Our ref: NO/2012/103476/01-L01
Your ref: 3/2012/0158
Date: 11 April 2012

**OUTLINE APPLICATION FOR THE ERECTION OF 73 OPEN MARKET
DWELLINGS AND 31 SOCIAL HOUSING PROPERTIES
SITE 2, BARROW BROOK BUSINESS VILLAGE, BARROW, CLITHEROE**

We **OBJECT** to the proposed development as submitted on the following grounds:-

PROPOSED SITE PLAN

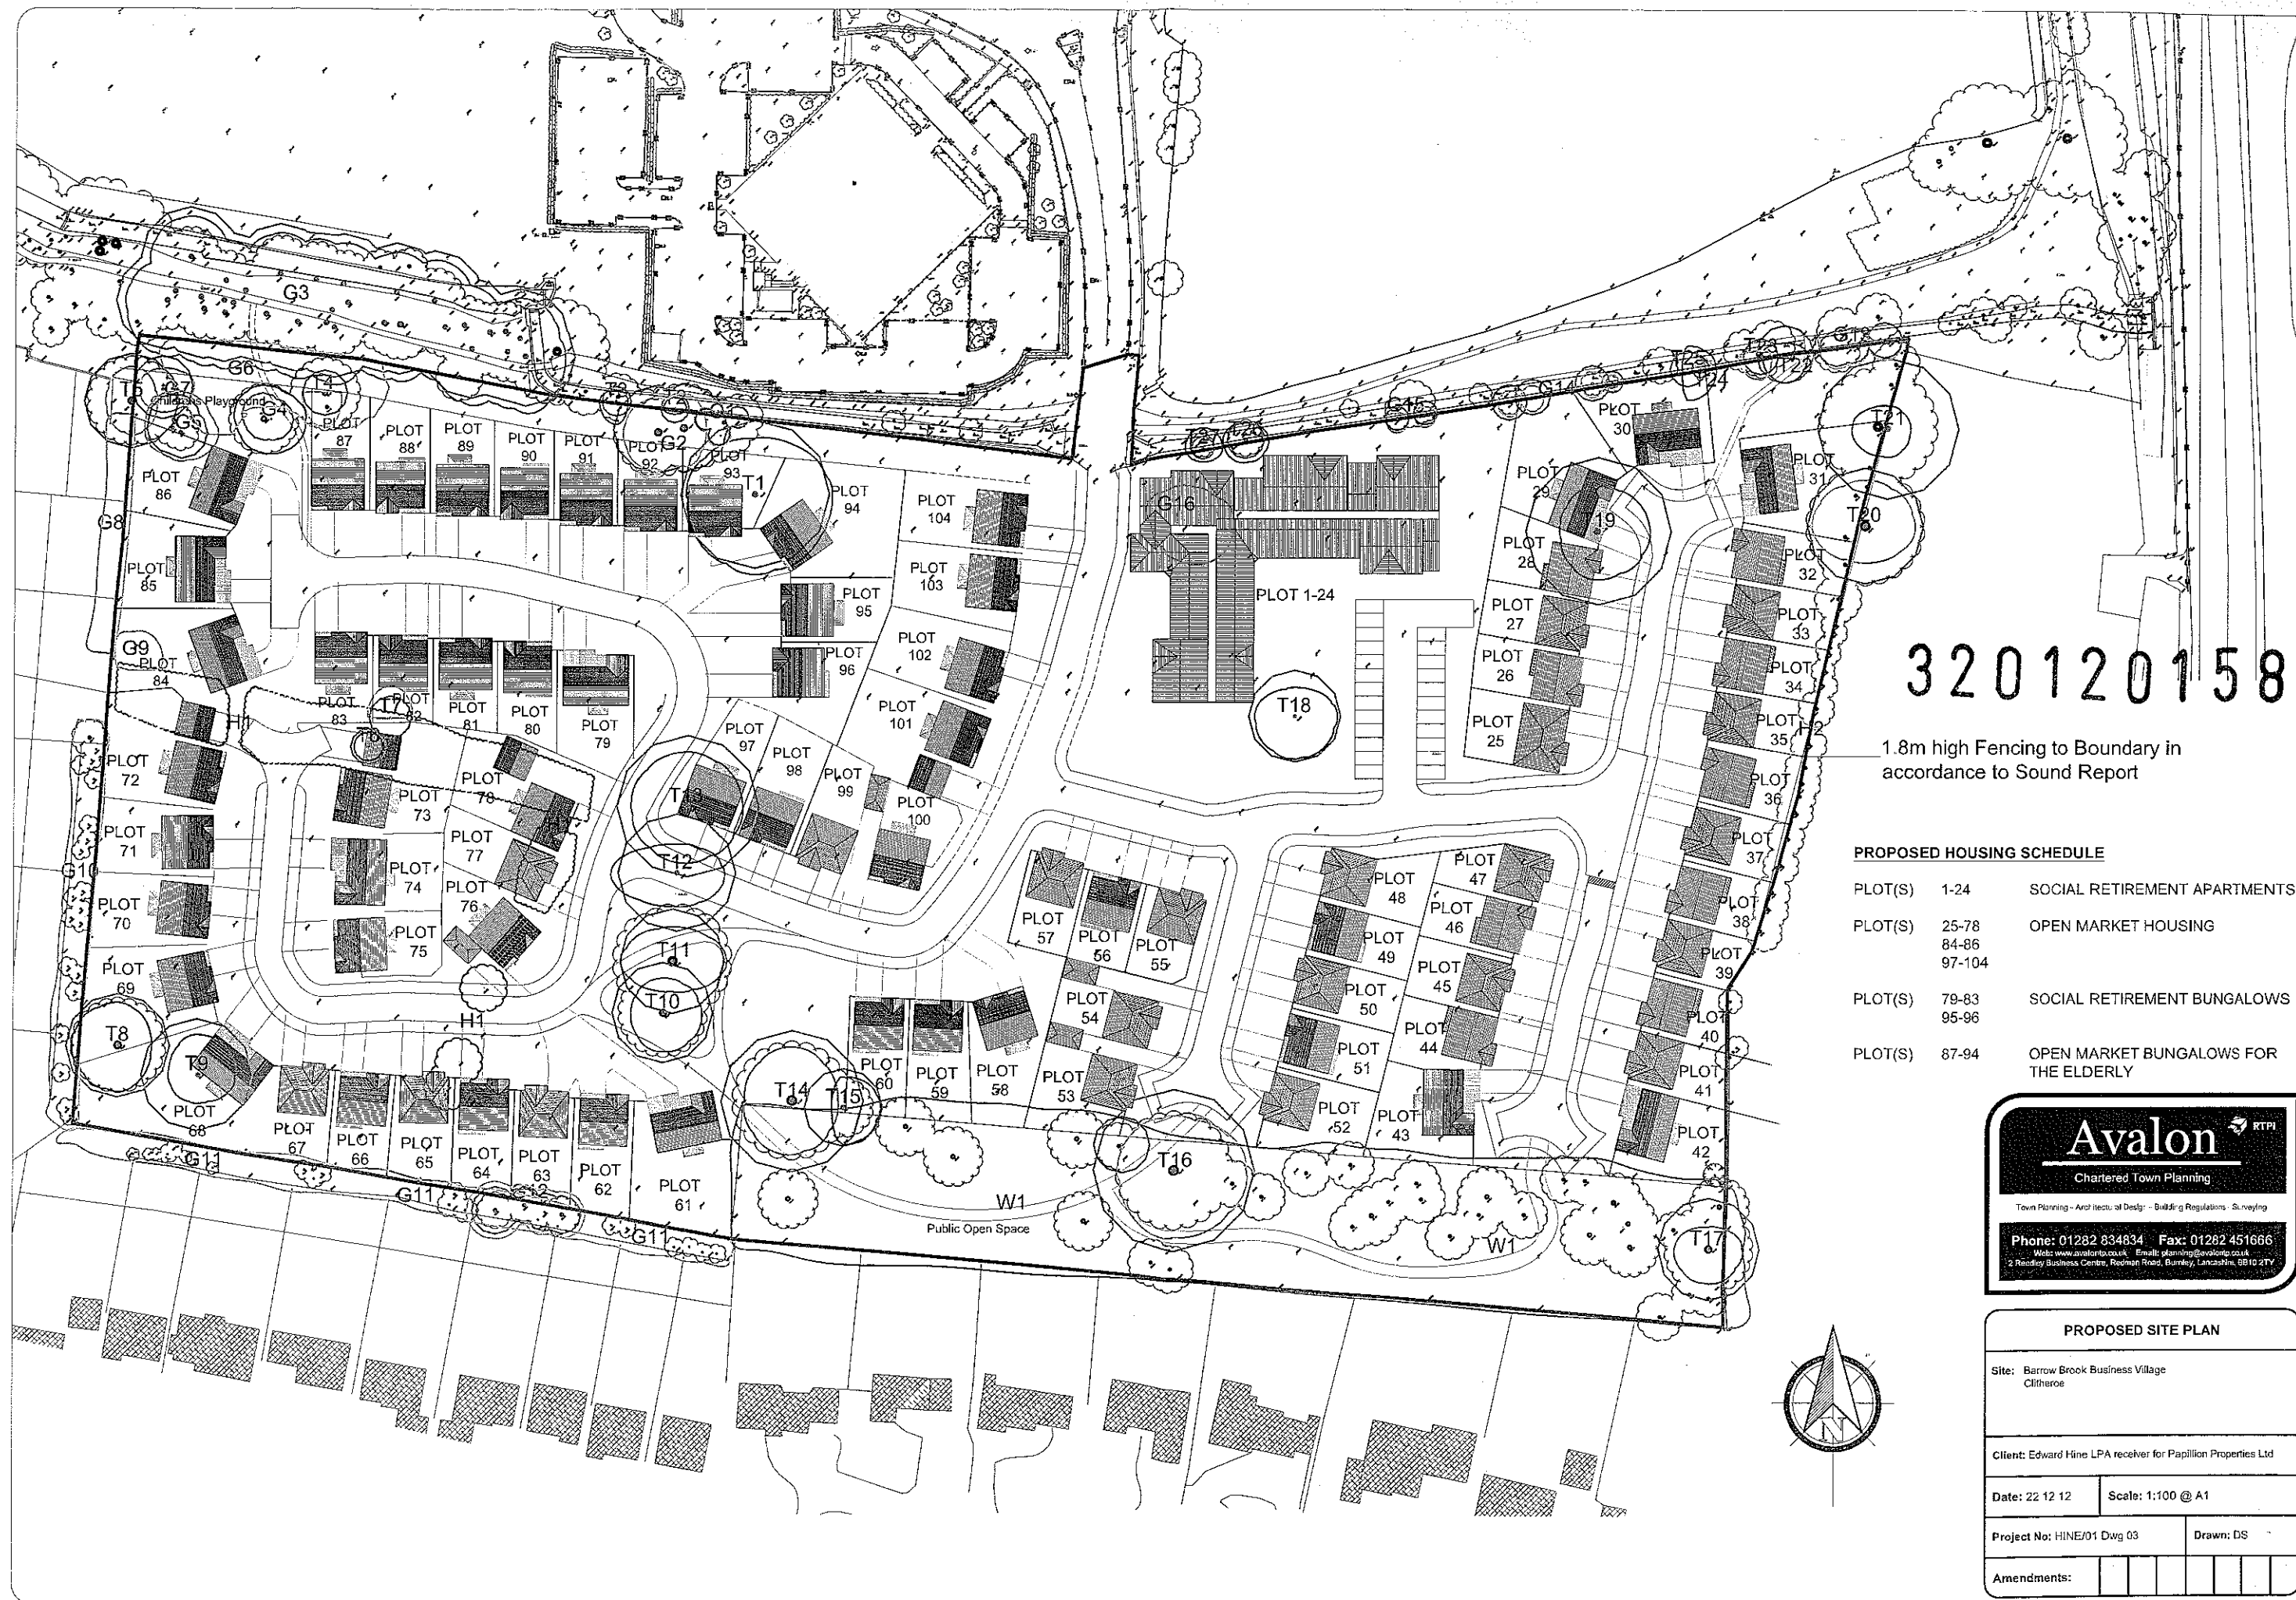
The proposed layout along the northern boundary of the western half of the site (plots 87-94, 104 & the playground) appears to provide a buffer between the watercourse and development, but the width of the buffer is not identified. The proposed layout along the northern boundary of the eastern half of the site (plots 1-24, 29 & 30) does not appear to provide a buffer between the development and the watercourse, with gardens hard up to the site boundary. The buffer zone should be kept clear of development, including fences, structures and car parking.

The proximity of the proposed retirement apartments to the watercourse is also unclear. The layout approved under application 3/2007/0964 demonstrated that no new buildings would be located within 8 metres of the watercourse. The proposed apartment block would appear to be closer to the watercourse than previously agreed.

are considered to be less damaging to the river corridor than the current proposal. In order to overcome our objection the applicant should submit an amended layout such that a naturally vegetated buffer between any part of the development and the watercourse is retained in order to preserve the integrity of the habitat corridor.
